Response to Submissions

Royal Rehabilitation Centre, Ryde

Frasers Putney

December 2011 ■ 09634

Figure 4: Tree Retention / Removal

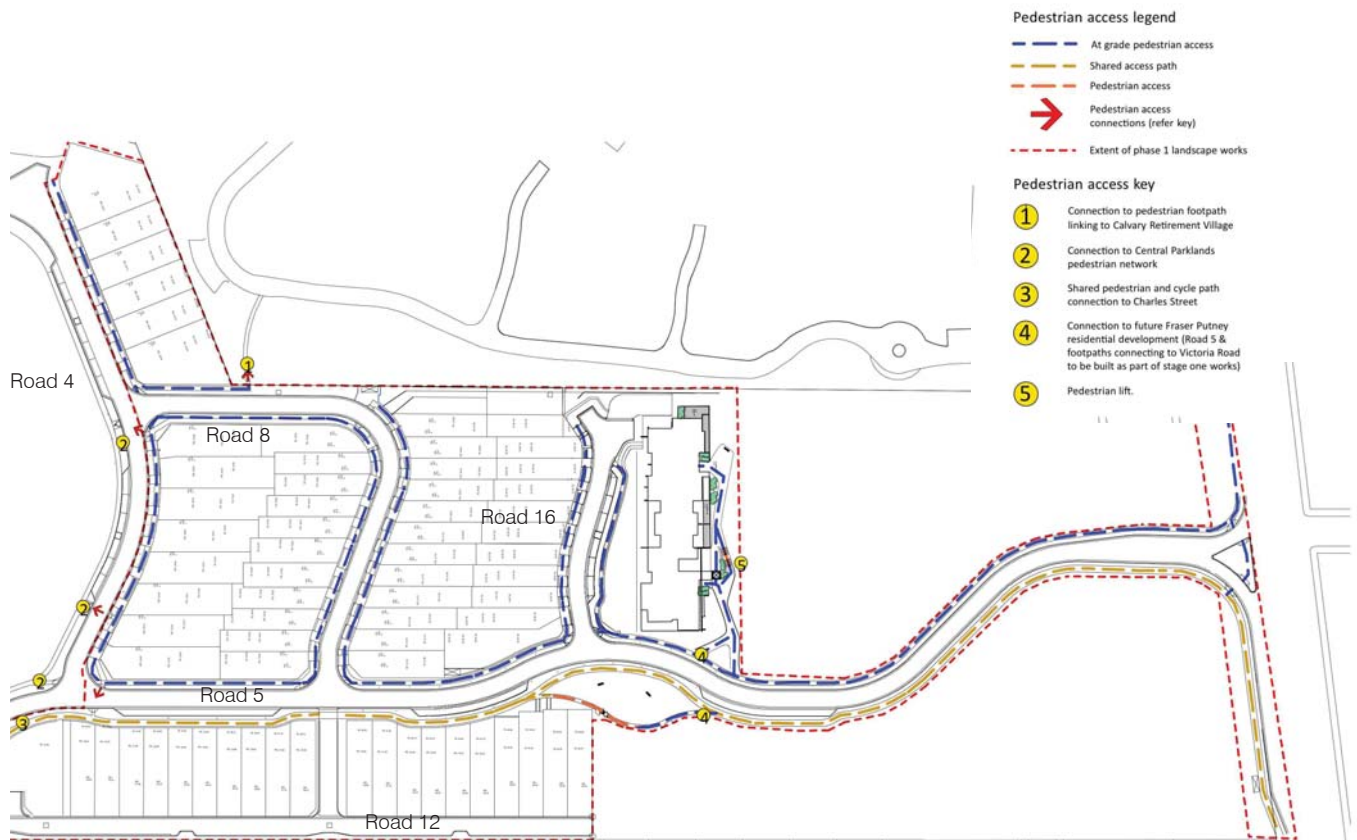
Concern is raised in relation to impacts on existing trees along Victoria Road, specifically the existing palm trees adjacent to Victoria Road and along the existing vehicle entrance off Victoria Road. The Arborist's Report (by Urban Forestry Australia) shall be modified to include details of the impacts of the section of internal 'Road 5', that is located north-east of the proposed residential development.

The Environmental Partnership Landscape Report (**Appendix H**) has been updated in lieu of the Arborist Report to include any details of trees affected by internal Road 5 where it crosses the north east of the overall RRCS site. Figure 4 within this report depicts trees to be retained/removed in the vicinity of Road 5. There is one tree outside the boundary of Stage 1 Phase 1 within the vicinity of Road 5 and this tree is marked for potential retention (retention to be subject to final levels/design at CC stage).
